**WEST SUSSEX COUNTY COUNCIL
STRATEGIC PLANNING CONSULTATION**

DATE: 19/10/2011

SUBJECT: FN/36/11 - Regeneration of dilapidated stable yard & associated buildings comprising 1 x holiday cottage & 2 x new dwellings (tog with replacement dwelling, ancillary stables & storage barn as prev. permitted under FN/37/09) to include revised vehicular access arrangements to provide seperate access for stables - amendment to refusal FN/83/10 (This application is a departure form the developemnt plan & lies within the SDNP Authorities)

Soldiers Field Stables, Soldiers Field Lane, Findon, West Sussex, BN14 0SH

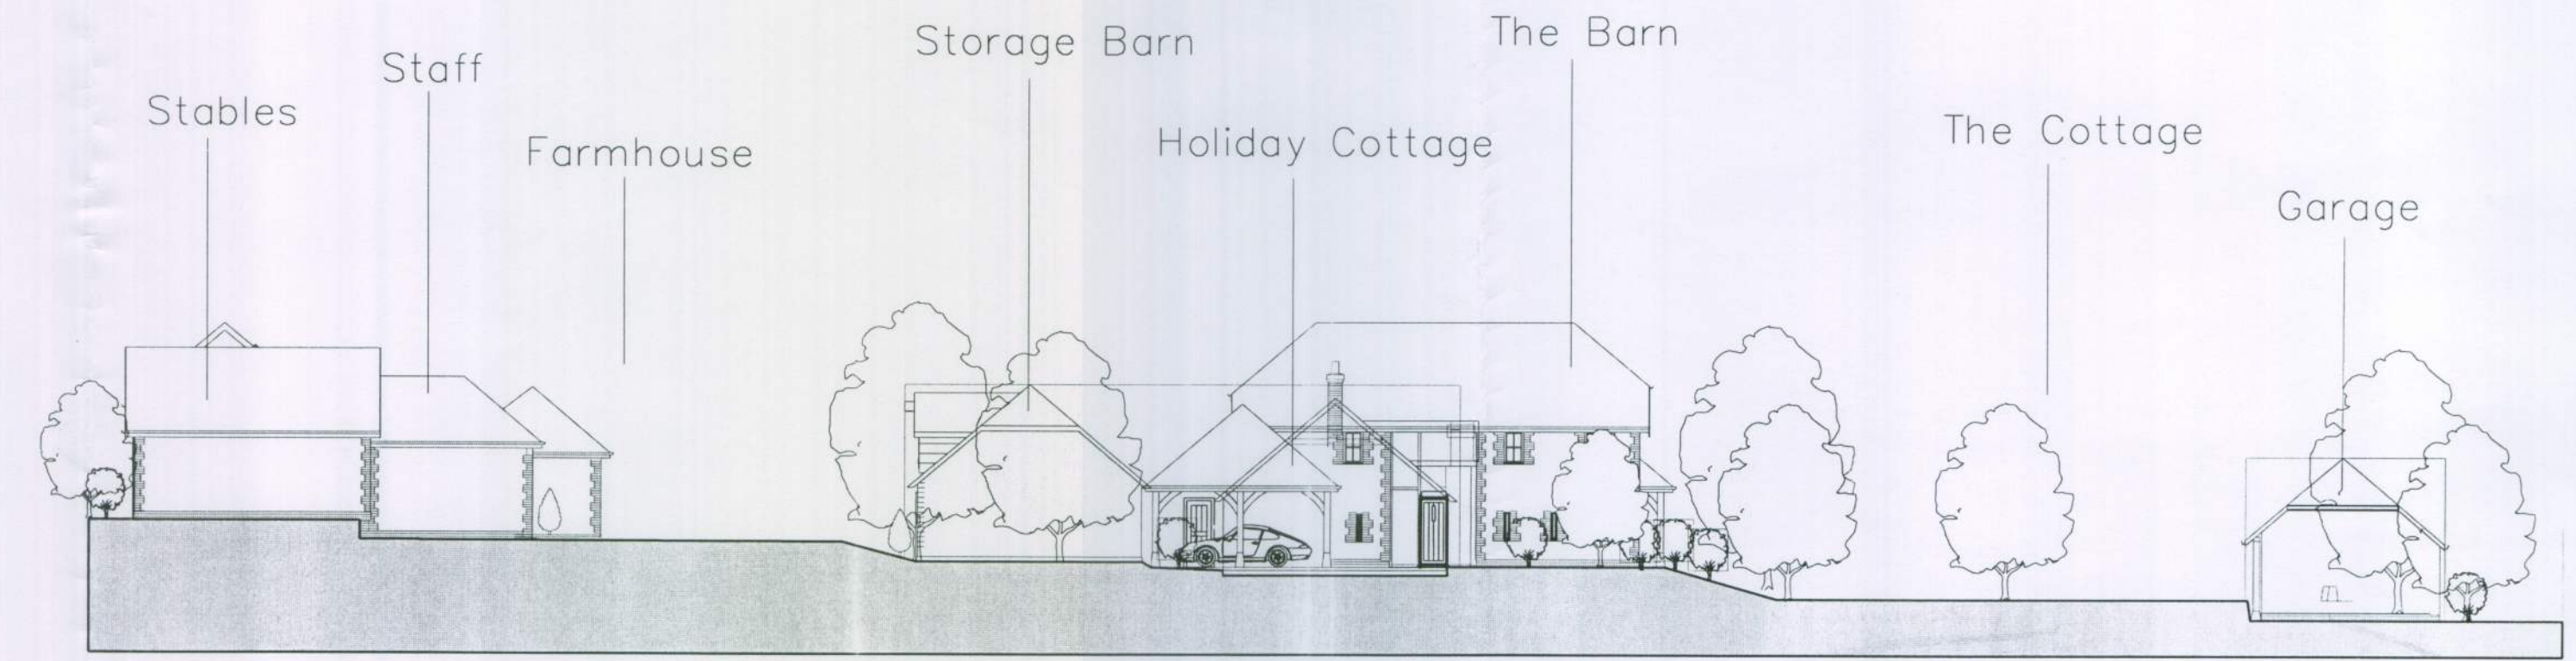
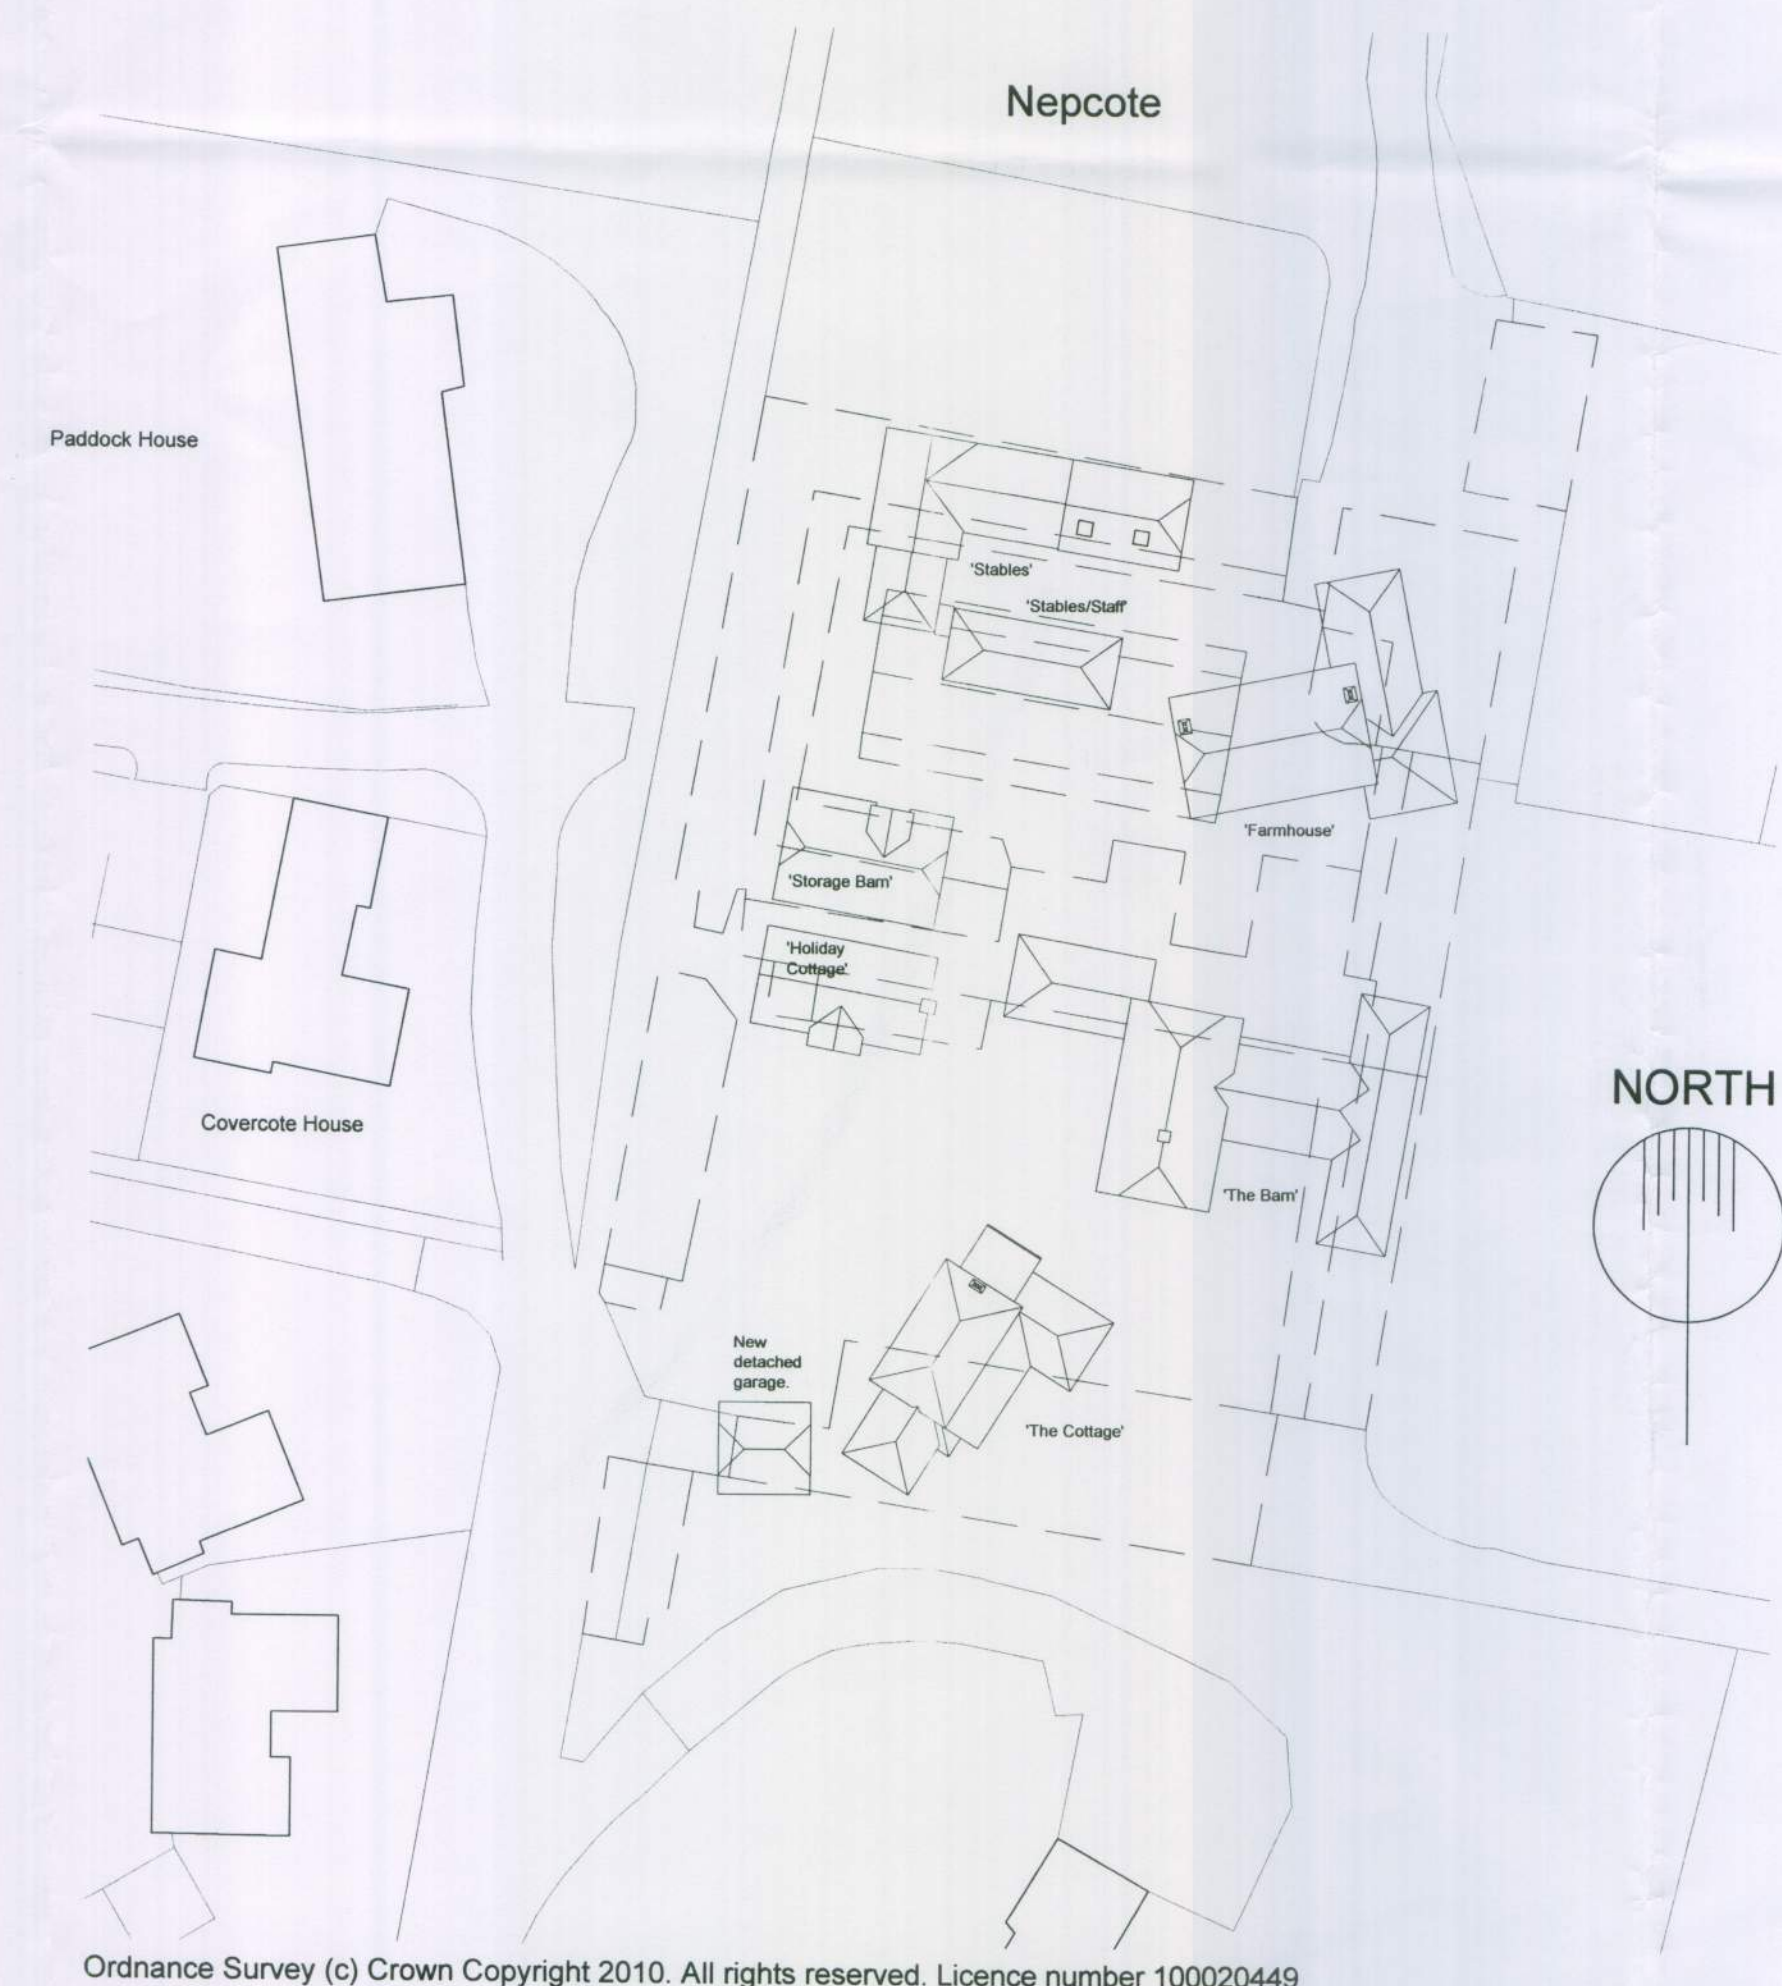
It is intended that the access arrangements are modified from the permitted plan to segregate the stable and holiday cottage traffic from the residential plots. This appears to be a change to the internal access arrangements. However, we have received advice from the Public Rights of Way Team regarding the impact of the development on Footpath 2085 which runs between the western boundary of the site and Paddock House. Whilst the traffic generated from this site is not likely to be materially different in terms of numbers from that generated by the permitted use at this site, it would be beneficial to make drivers leaving this site aware of the possible presence of footpath users. A condition should be included to secure the erection of a suitable sign; the wording of which should be agreed by the LPA in consultation with the WSCC Public Rights of Way Team.

Informatives and conditions should also be applied as suggested under application FN/37/09.
